## **Great Wolf Resort Proposal – 19/02550/F**

### **Bicester Delivery Team, Cherwell District Council – Comments on the Travel Plan/Transport Assessment**

Title:  
Proposed Shared Foot/Cycleway

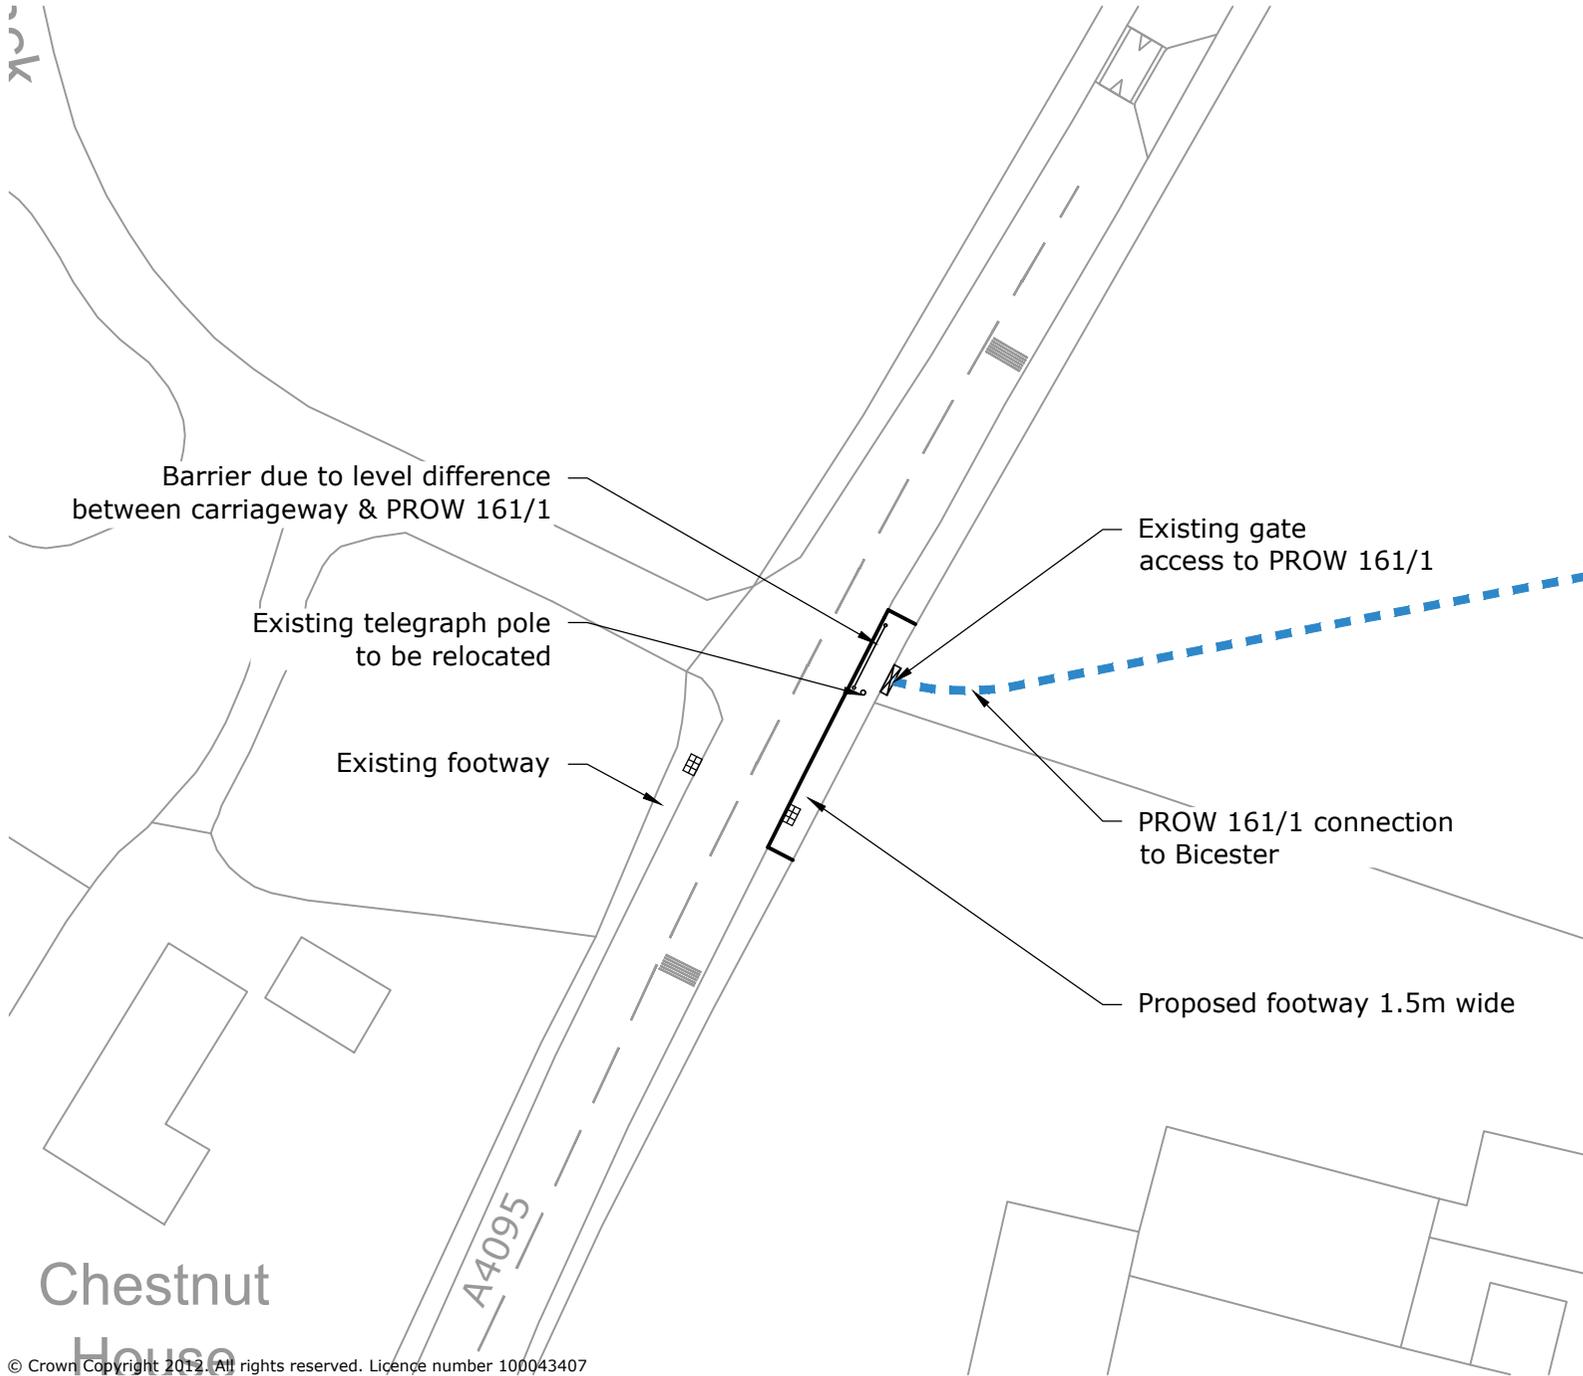
Bicester Town Centre is within a comfortable cycling distance (approx. 5km) from the proposed development. The proposals include the provision of a 2.5m off-road shared cycling facility on the southern side of the A4095 beginning to the west of the main access and finishing at the edge of the village of Chesterton. As such the proposed level of improved provision is for access to Chesterton only with the route between Chesterton and Bicester necessitating the cycling on carriageway with high traffic speeds (unrestricted speed limit and unlit) and in the case of the route north to Vendee Drive, high traffic volumes which will be further exacerbated by the proposals. Furthermore, the 2.5m width of the proposed shared use facility is defined as the minimum provision as opposed to what is recommended within the Oxfordshire County Council Cycling Design Standards.

Further enhancements would be required to provide a safe cycle route to connect with the network of cycle routes on the periphery of Bicester (Vendee Drive and the A41).
